Conversion of part retail unit & storage area to form 9 No. residential units consisting of
3 No. 1 bed & 6 No. 2 bed dwellings & new access to rear.

107 Felpham Way Felpham

Thank you for your internet representation made on 29th March 2019 which has been recorded as '**an objection**' with the comments as follows:

SITE PLAN (Proposed) @ 1:200

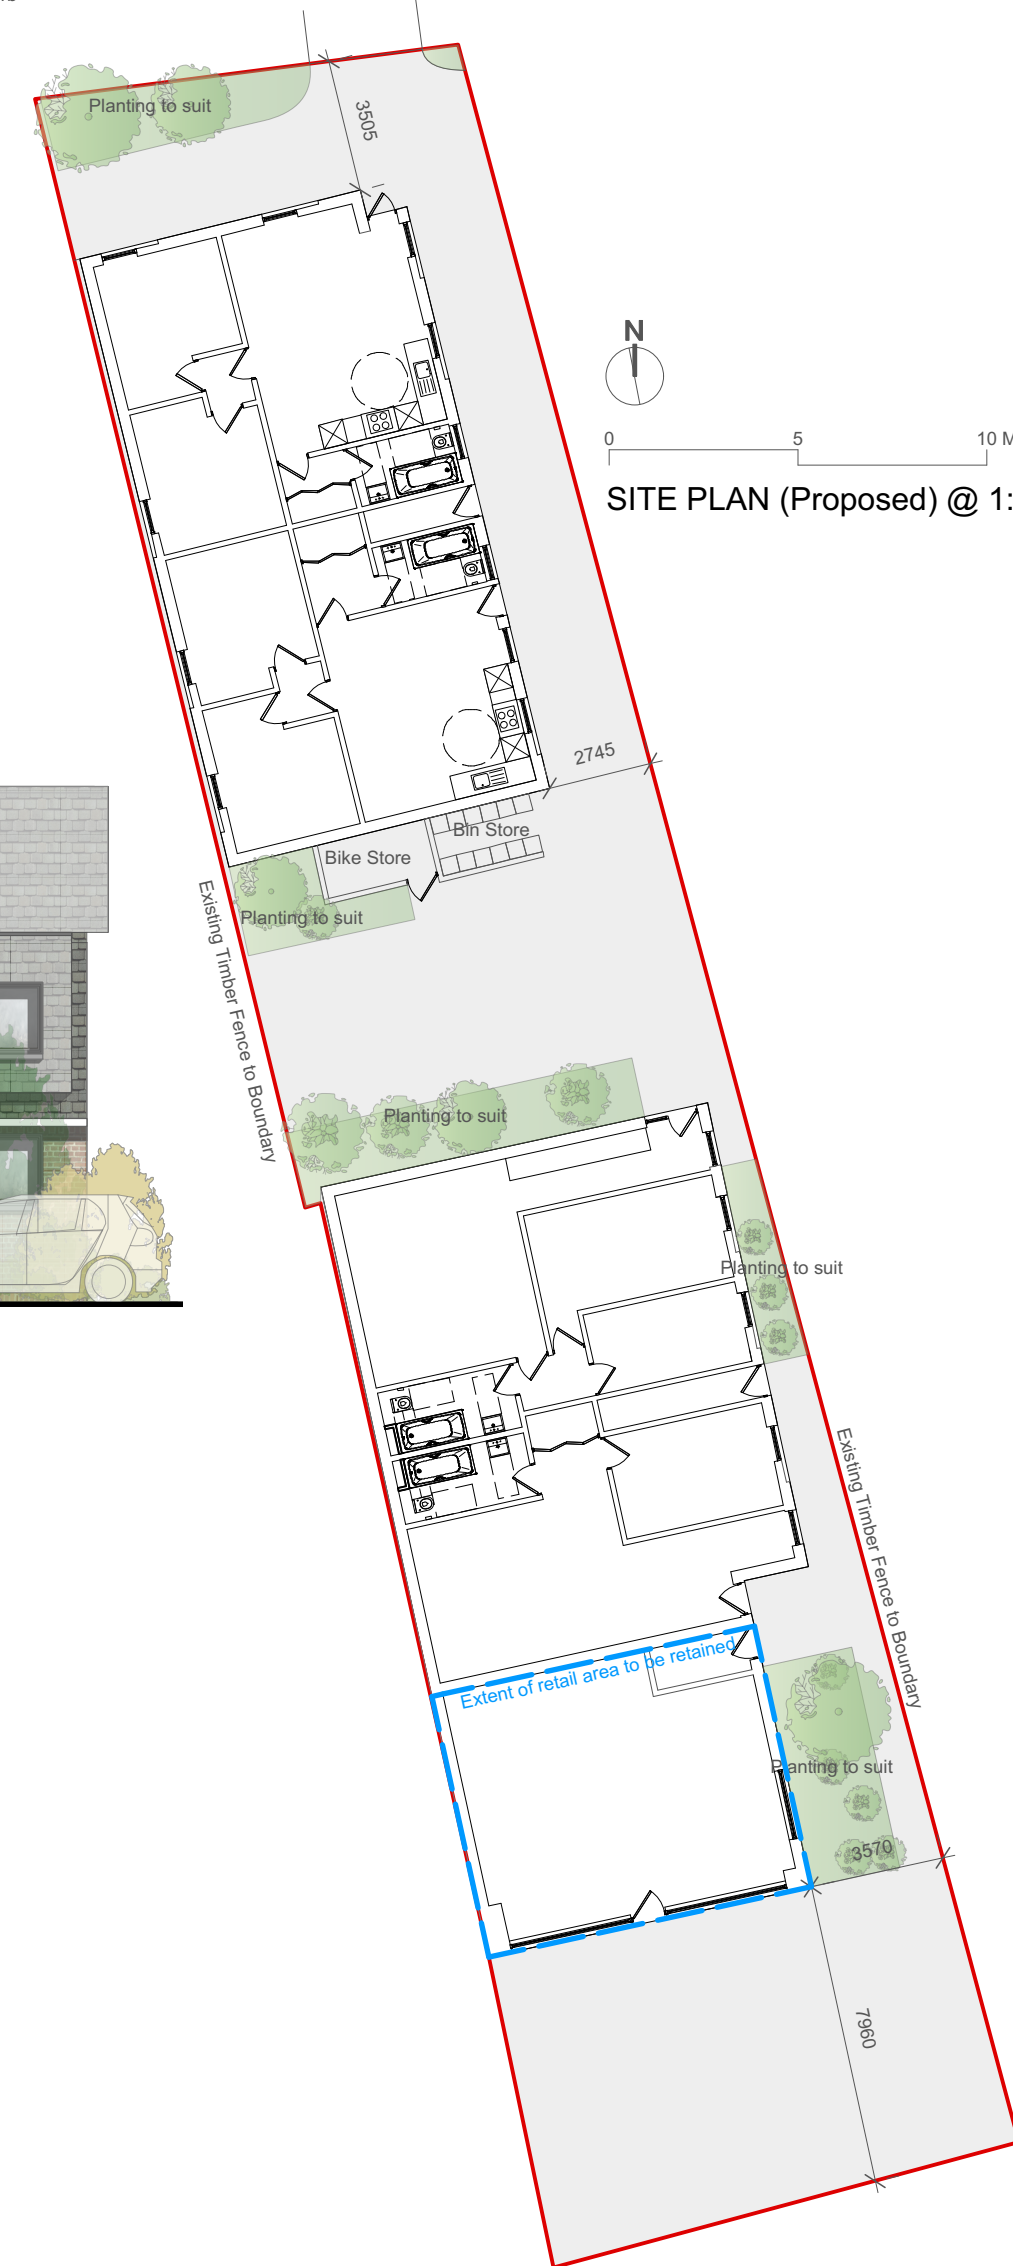
1 The northern block touches the boundary of 1 Rainbow Cottages, this would mean all privacy in the garen and rear rooms of 1 Rainbow Cottages would be lost; unless all overlooking windows were of obscured glass. Alternatively the block should be move further east, unfortunately this would then cause similar problems to 2 Sunnyside cottages.

2 Parking spaces for 9 flats. We would anicipate approximately nine vehicles have not been provided for within the boundaries of the development. Given 6 of the proposed flats are for 2 bedroom flats one should work on the principle that a possible 15 cars could need to be accommodated, without the need for visitor parking.
